Application for a Non-Material Amendment Following a Grant of Planning Permission

Demolition of existing garage, two storey side extension, single storey rear extension, roof alteration to rear elevation and internal alterations.

20/0484/HH

A small window adding to the rear of the utility room on the ground floor

job no: **1909P059** drg no: **300E**

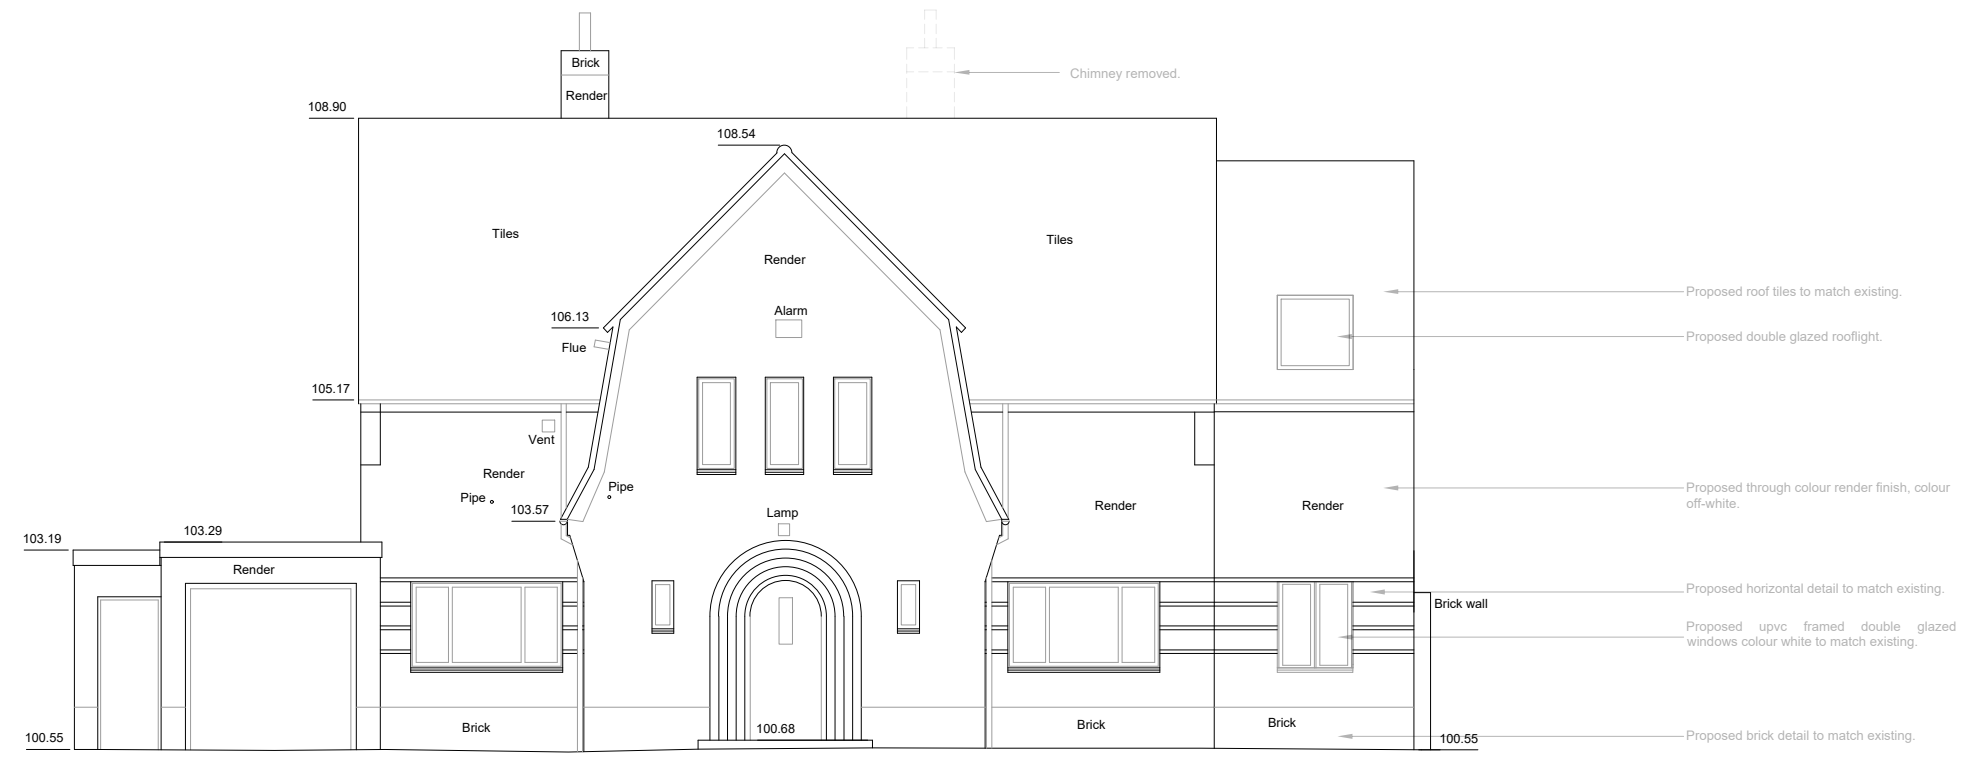
Additional natural light into the utility room

1909P059 - 200E- Proposed Plans
1909P059 - 300E - Proposed Elevations
